From: Martyn White <Martyn.White@arun.gov.uk>
Sent: 19 May 2020 17:34
To: Planning.Responses <Planning.Responses@arun.gov.uk>
Subject: LU/46/20/PL

LU/46/20/PL

Littlehampton Covered Market 26-28 Surrey Street Littlehampton BN17 5BG

Demolition of existing building & construction of 1 No retail unit & 3 No. flats with associated external works & access. This application affects the setting of listed buildings & may affect the character & appearance of the River Road, Littlehampton Conservation Area.

Proposed Plans And Elevations

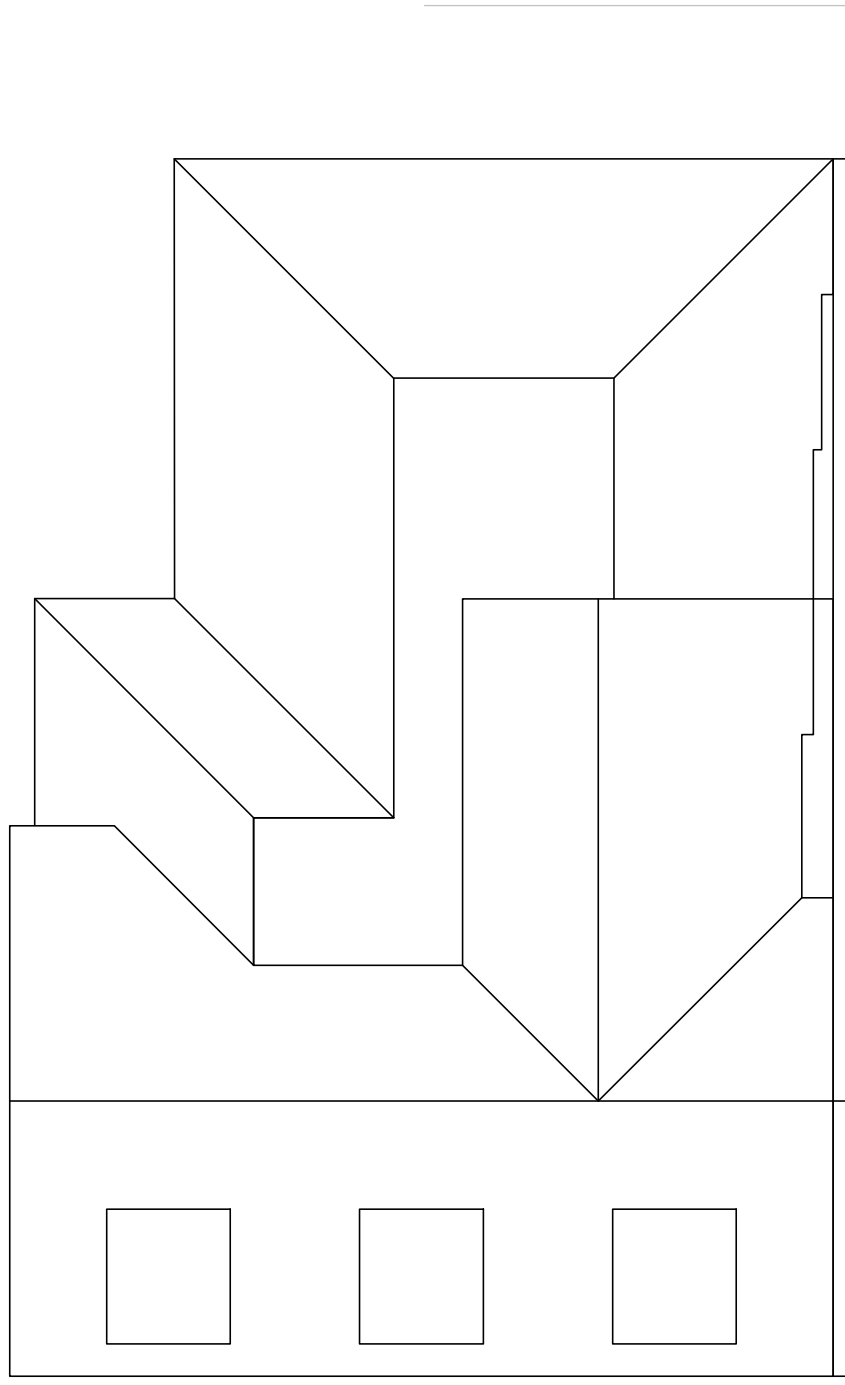
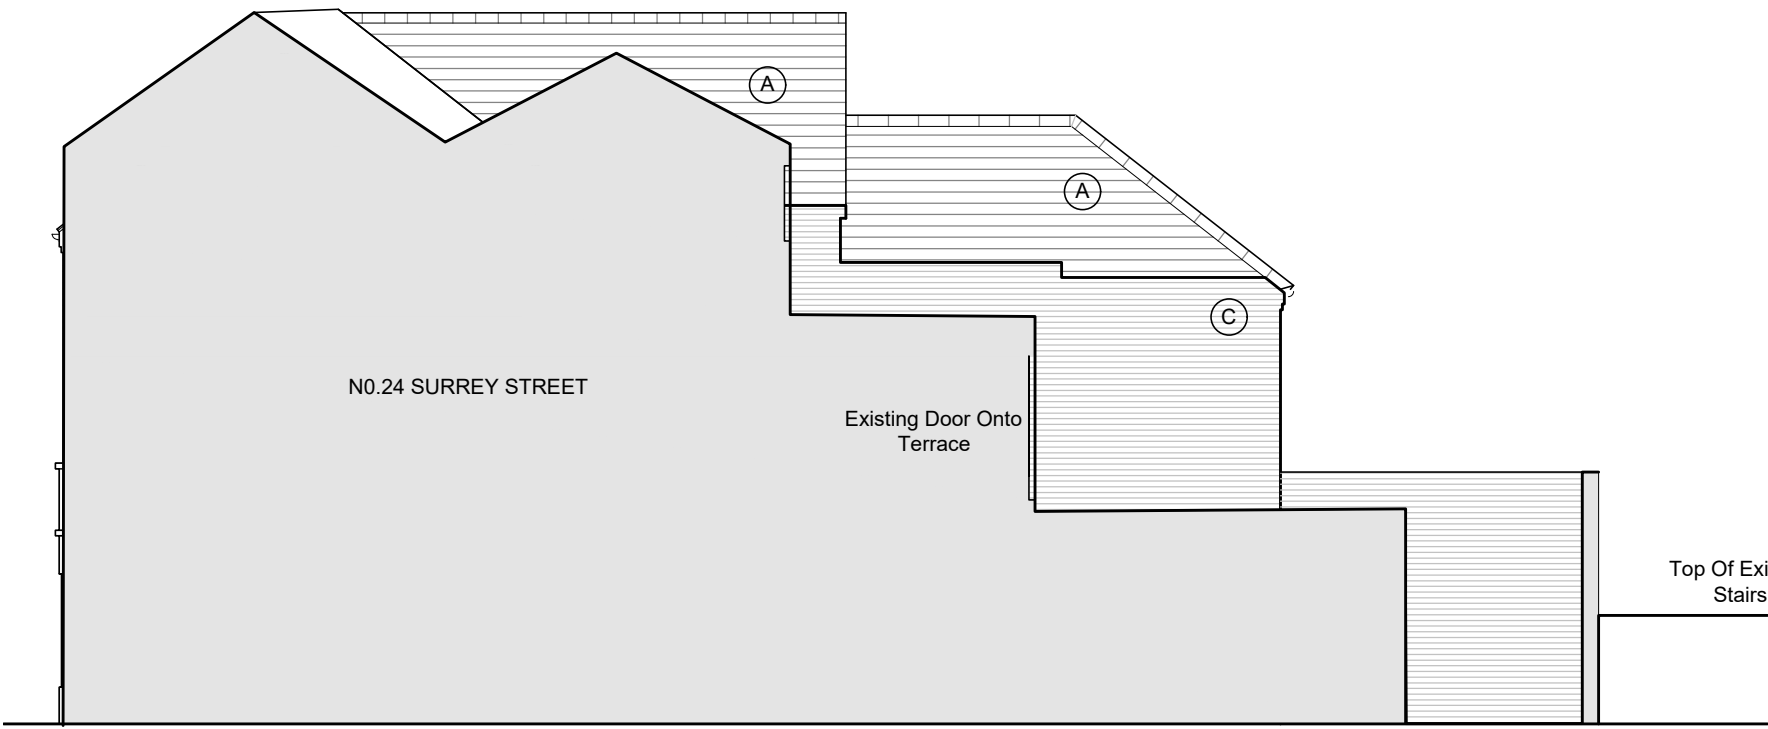
The proposed building is of a generally acceptable design, which if built to a high standard could have a positive impact upon the street-scene. However, I do have some concerns. Whilst of a similar height to 20-24 Surrey Street, it would be taller than the neighbouring public house. Further the proposed southern elevation would have a more dominant impact upon the street than the present elevation which has a hipped roof.

The proposed materials are also of concern, for instance the use of false slate tiles, and White sash effect windows. Windows should be functional vertical sliding sashes, as opposed to being styled as vertically sliding. Whilst it is noted that details of materials and joinery can be conditioned, the proposed materials are not considered to be appropriate for the sensitive location. It is also not clear why the elevation of the proposed building is to be constructed using brick; the existing elevation is painted render. If brick were to be used, it would have to be of high quality and in an appropriate bond to reflect its position next to two listed buildings.
